Permit Number: 061103

has permission to Build new Garage & Breezer

AT 30 MARLBOROUGH RD

Dept: Building **Status:** Approved **Reviewer:** Residential Plan Review **Approval Date:** 08/29/2006**Note:** **Ok to Issue:**

GARAGE CROSS SECTION

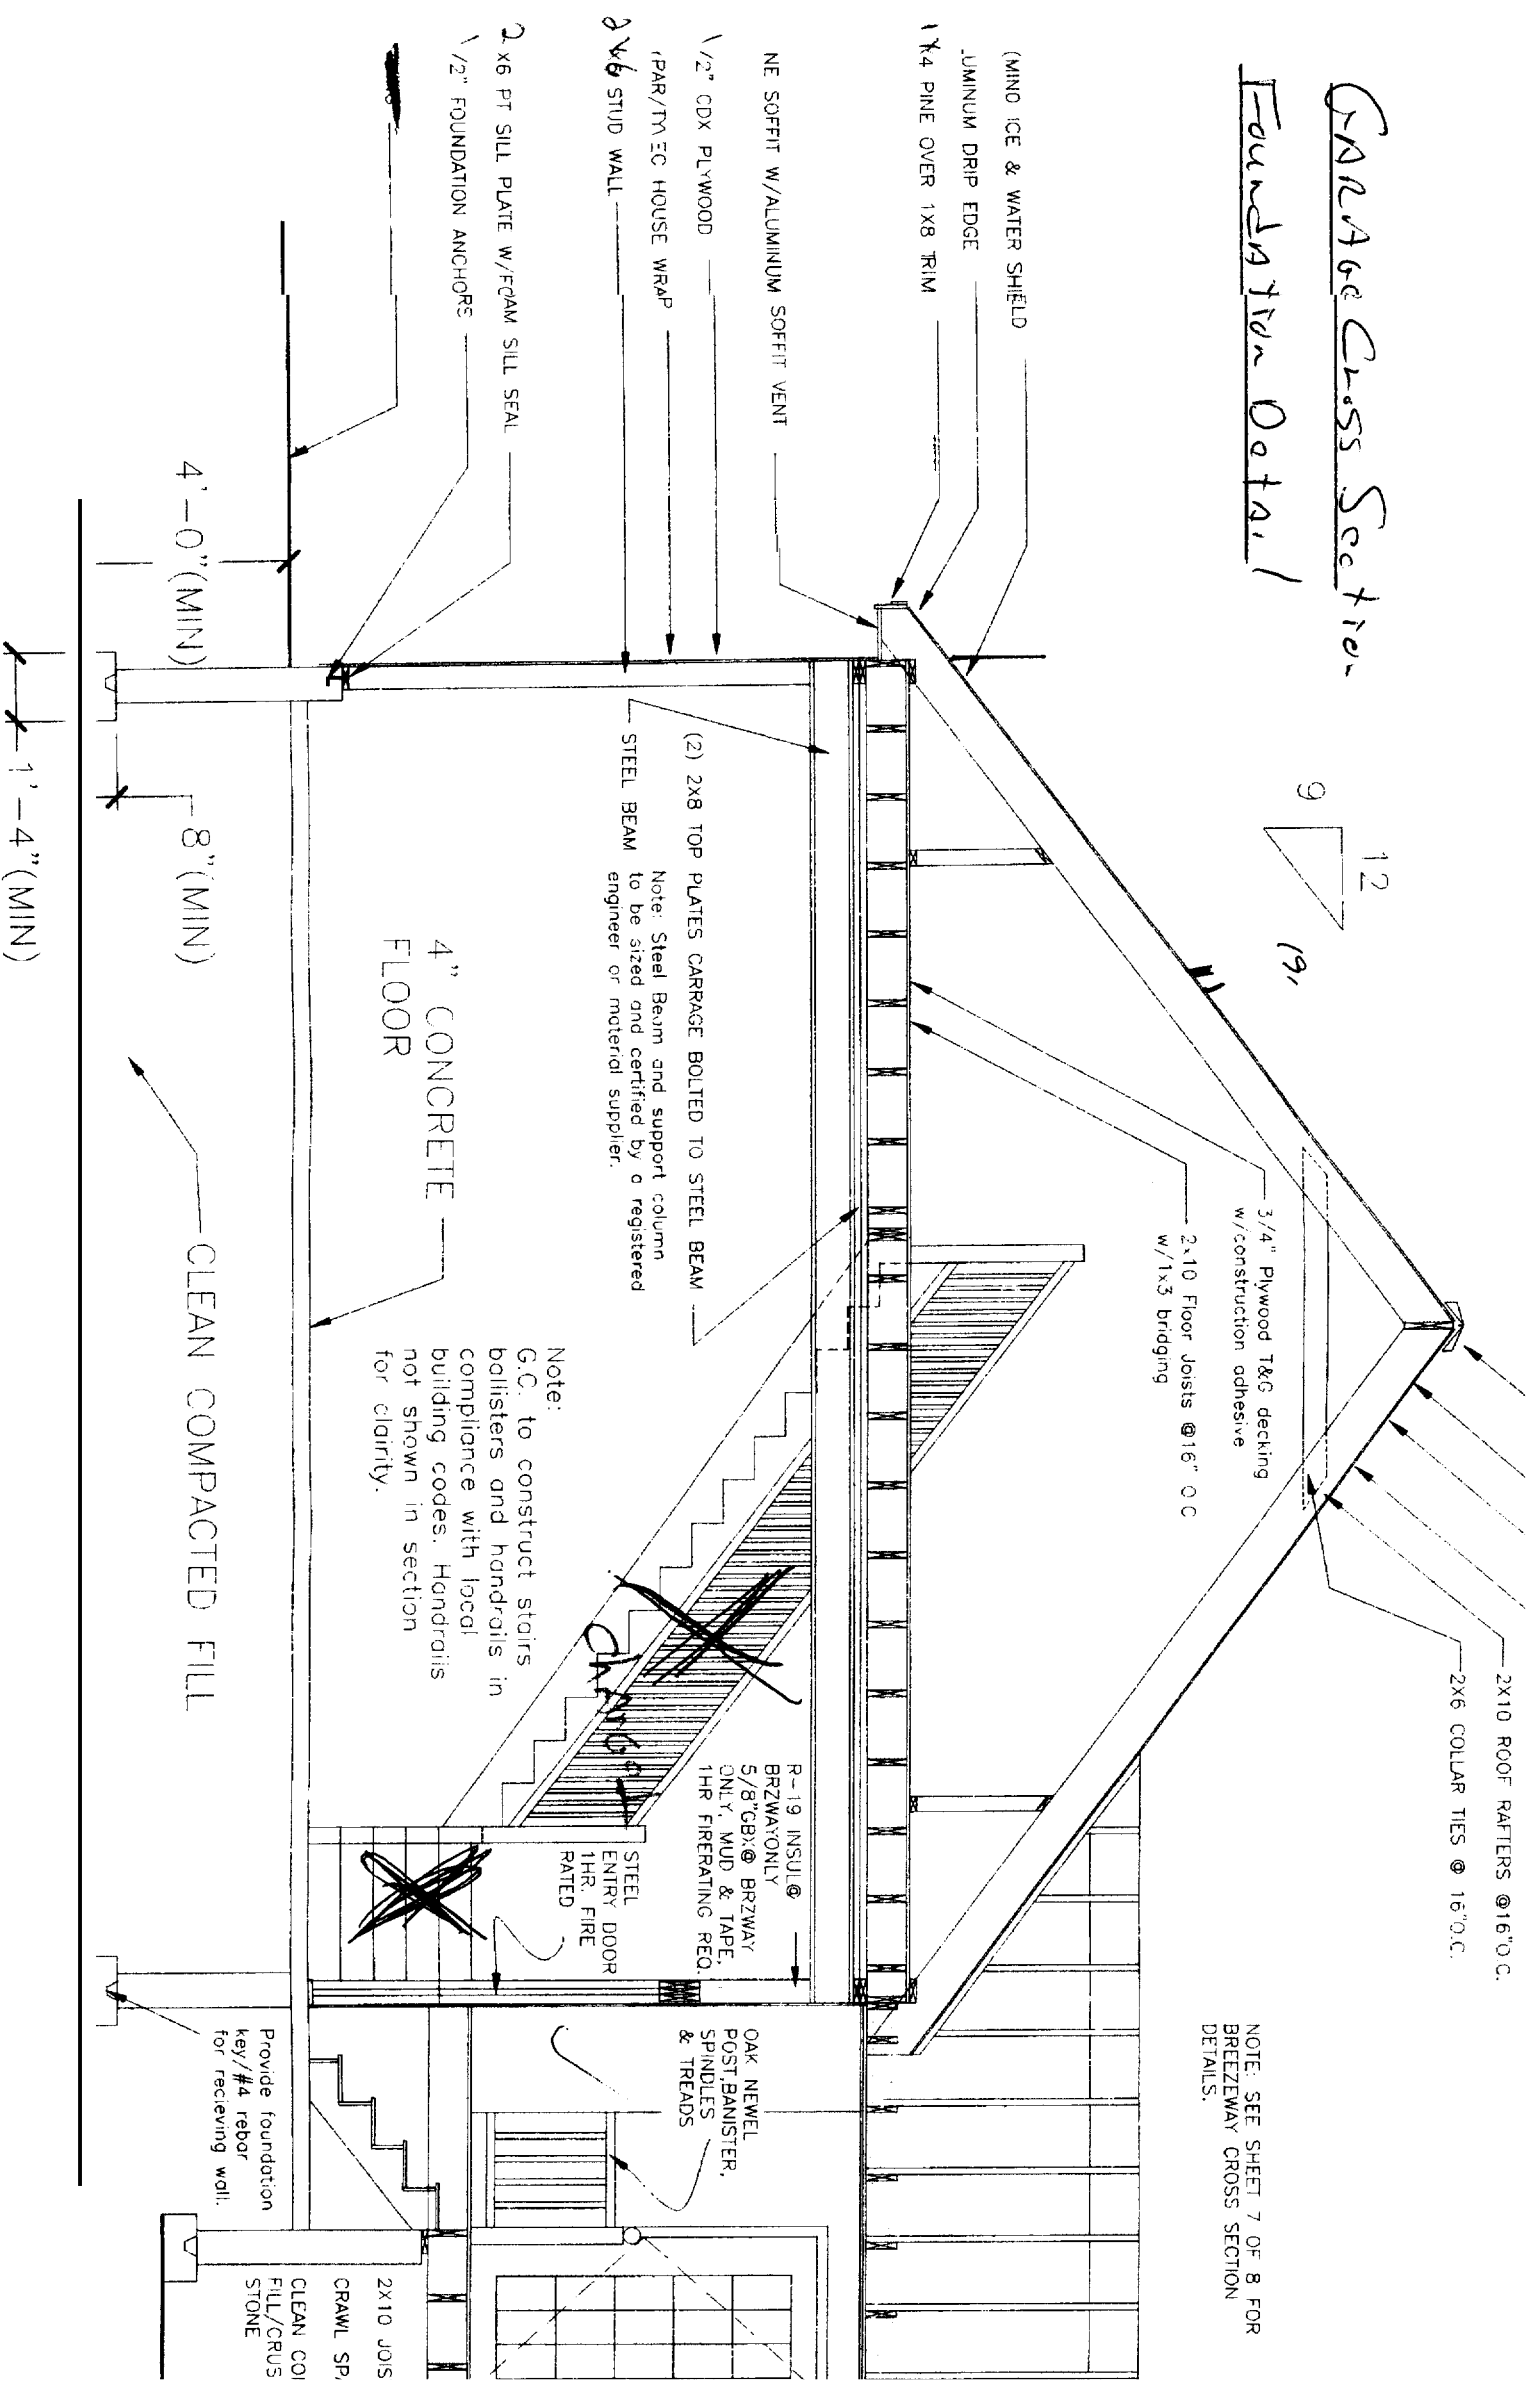
- 1) Separate permits are required for any electrical, plumbing, or HVAC systems. Separate plans may need to be submitted for approval as a part of this process.
- 2) Application approval based upon information provided by applicant. Any deviation from approved plans requires separate review and approval prior to work.
- 3) The design load spec sheets for any engineered beam(s) must be submitted to this office.

Stair construction in the garage will be changed from the print to a framed and sheet rock wall with a hand rail.

All stair construction to meet 2003 IRC Section R31 1.5.3

TREAD & RISER DIMENSIONS
ONE & TWO FAMILY
2003 INTERNATIONAL RESIDENTIAL CODE
SECTION R311.5.3 TREADS & RISERS

In occupancies in 1 and 2 family dwellings (**Use Group R-3**) and in accessory occupancies (shed, garages, etc.) to 1 and 2 family dwellings the following are the tread and riser requirements:

The **MAXIMUM** riser height shall be **7 3/4"** and the minimum riser height shall be **4"**. The **MINIMUM** tread **depth** shall be **10"** (measured from leading edge of tread to leading edge of tread). A nosing not less than **3/4"** but not more than **1 1/4"** SHALL be required on treads where the depth is less than **11"**. Openings in risers shall not exceed **4"**.

Please note: To achieve a minimum 10" net tread the stringer must be cut to 10".
